Planning Application Ref: Y/91/17/OUT

Location: Land at Bilsham Road, Yapton

Description of works: Outline application for the development of up to 250 residential dwellings (Class C3) vehicular access, public open space, ancillary works and associated infrastructure. Departure from the Development Plan

Comments on Application:

- Key.
- RPA for CAT A\* tree to be retained
  - RPA for CAT B\* tree to be retained
  - RPA for CAT C\* tree to be retained
  - RPA for CAT U\* tree to be retained
  - Canopy of tree to be retained
  - Canopy of CAT U\* tree to be removed

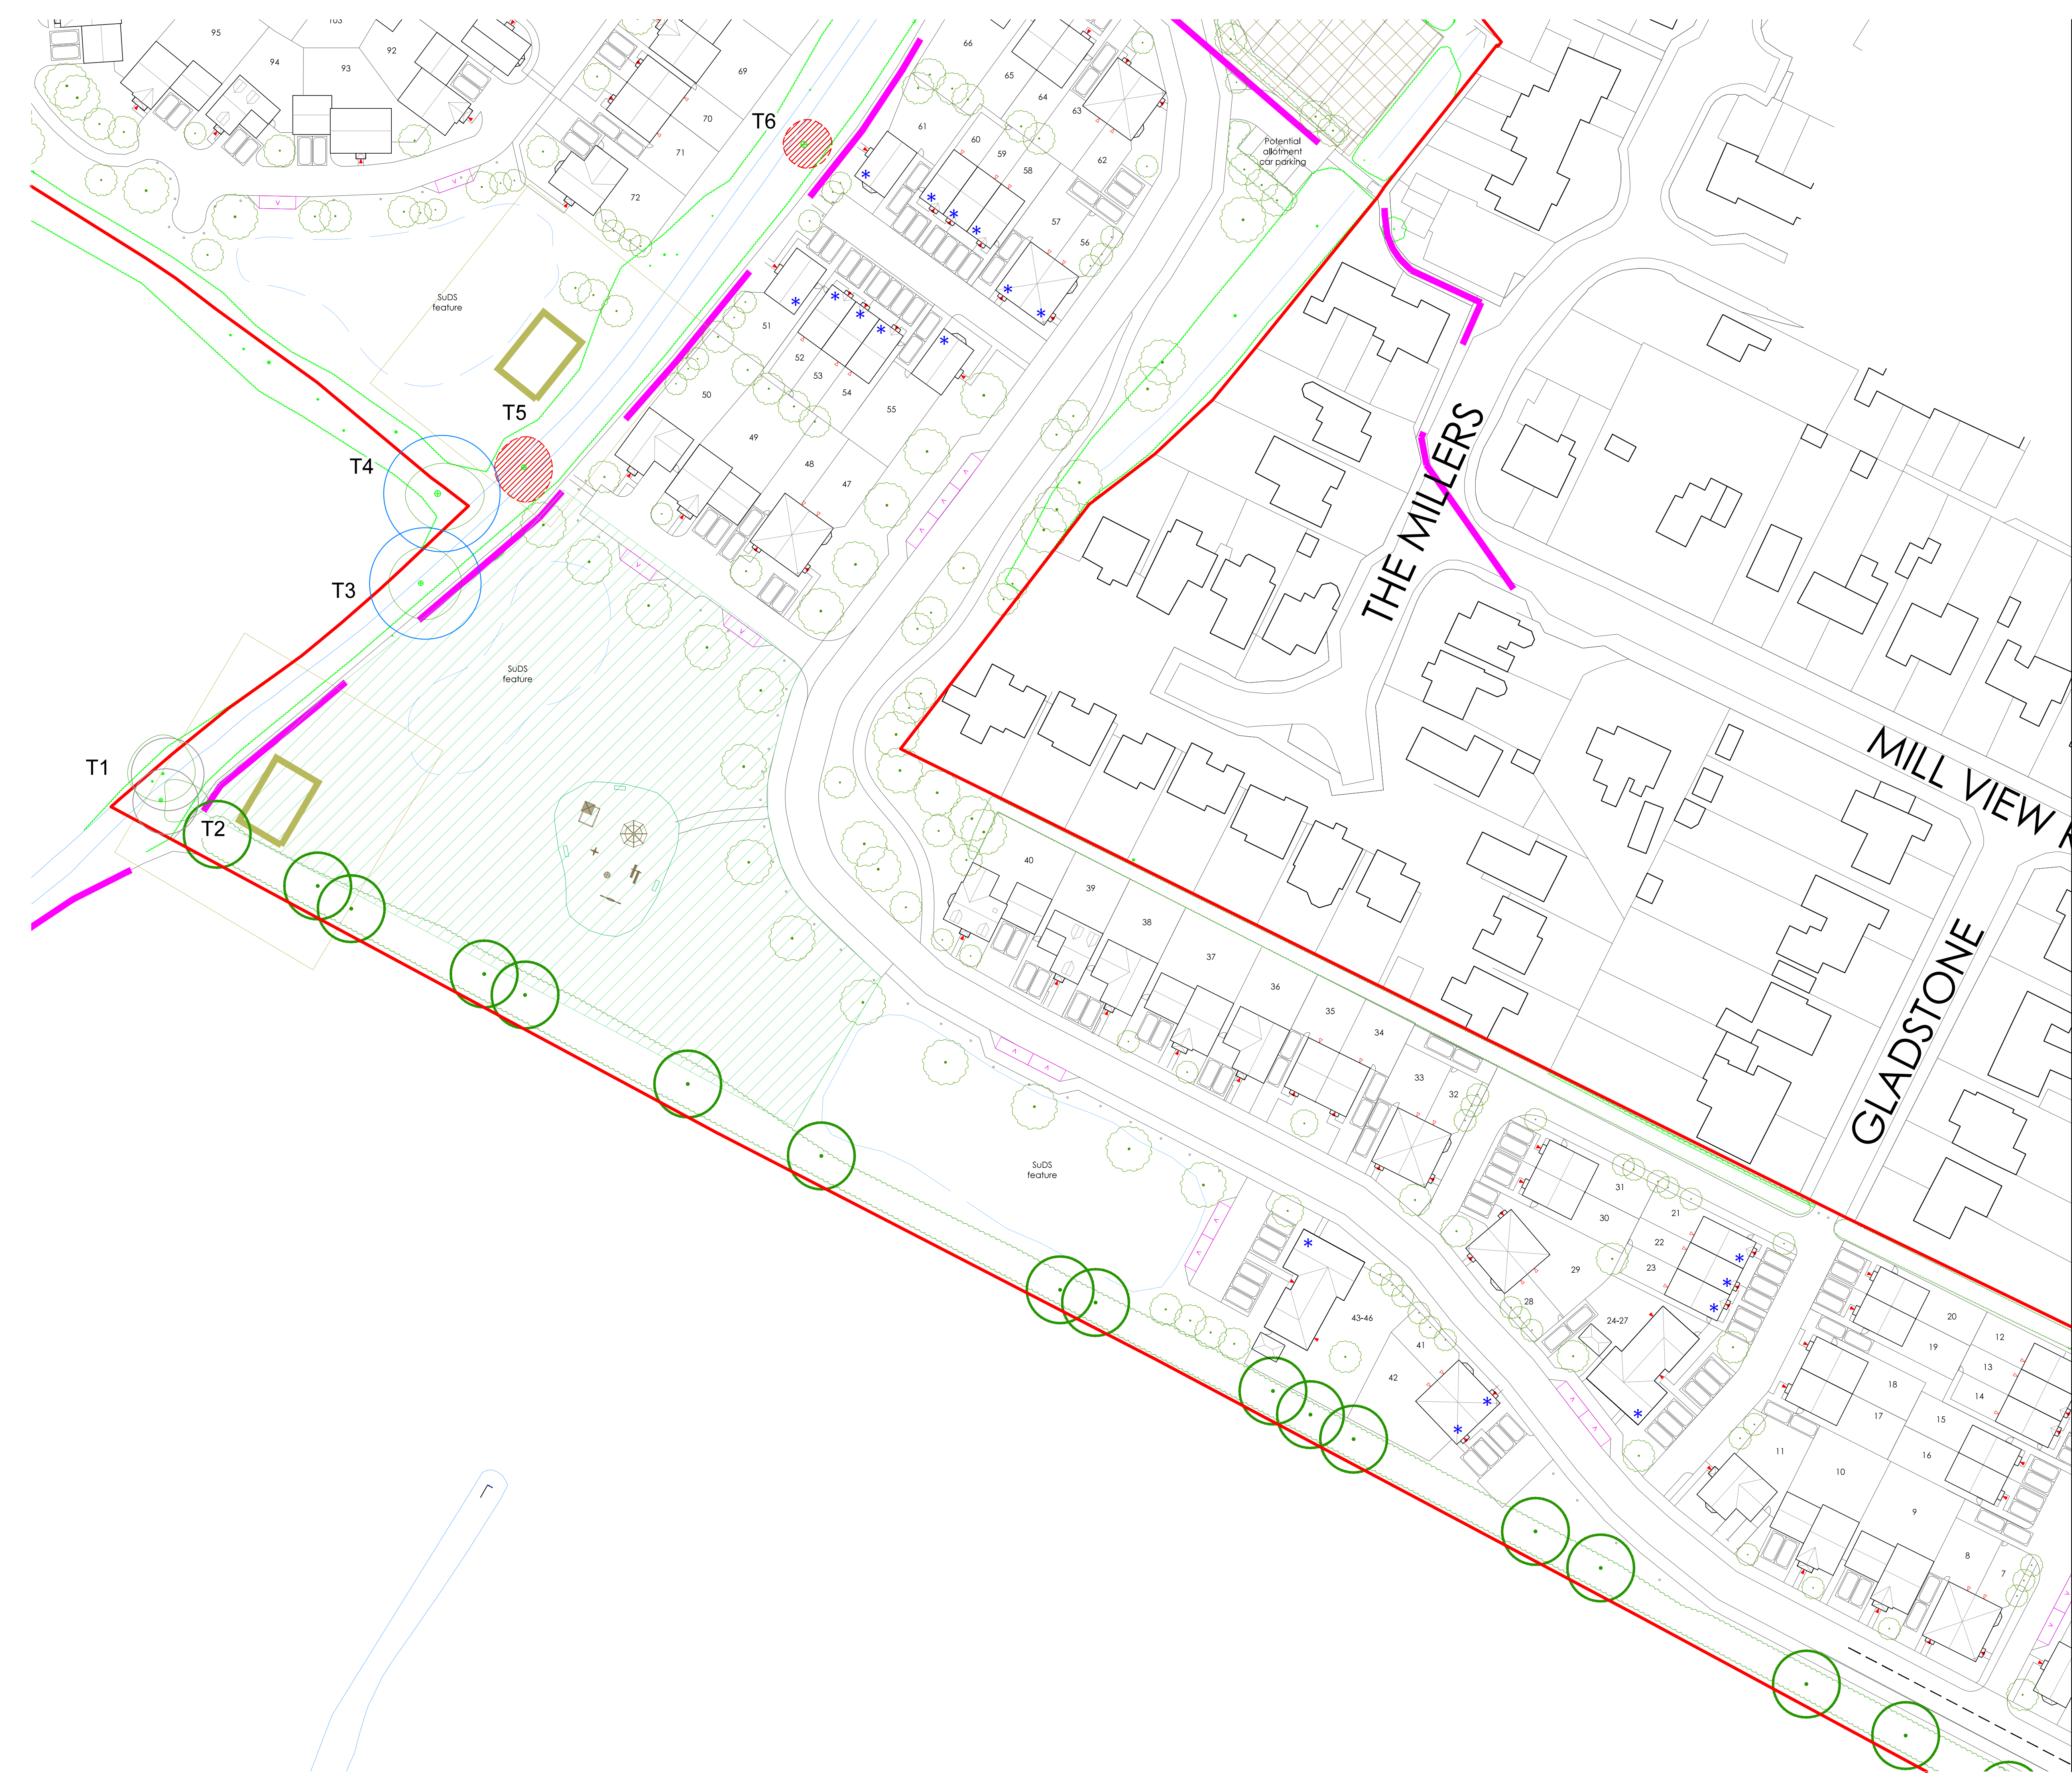
- The applicants employed the PJC Consultancy back in November 2017 to undertake a tree survey and then prepare an Arboricultural Impact Assessment (AIA) PJC/4699/17-02 R2. Tree Survey data is adequate at this stage and broadly accords with the requirements of BS5837:2012. I have referred to Illustrative detailed masterplan drg. 1244G.03 to assist with determining the accuracy of the Tree Constraints and Tree Retention Plans submitted by PJC with their AIA report. This allows me to gain a general understanding of how the plot layout and access routes relate to trees but is not specific enough for me to have full confidence they will be adequately respected and protected.

- I am pleased to see there is intent to retain the vast majority of recorded trees in harmony with the development, but I cannot be satisfied that this will be achievable until we receive a Tree Protection Plan (TPP) overlaying the final proposed site design layout, with supporting Arboricultural Method Statement (AMS) where RPA incursion is anticipated - which I would expect to see submitted with a subsequent full planning application.

- At this outline stage, the indicative layout and access arrangements and the appointed arboriculturalist's general regard for significant trees existing on site are encouraging and I am in broad agreement with their survey information. That said, I am concerned that there appear to be notable omissions in respect of existing tree cover along several sections of the site perimeter (South, adjacent arable farmland – East, rear of The Millers – North, south of dwellings at Tack Lee Road). This may be deliberate as the proposed design does not at this stage suggest any direct interference with them but it is important to consider all trees whether they are on or off-site and within potential influencing distance, so as to inform the site layout design which may of course be subject to revision. Any omissions will need to be addressed and therefore included in the aforementioned TPP and AMS should this proceed to a full planning application.
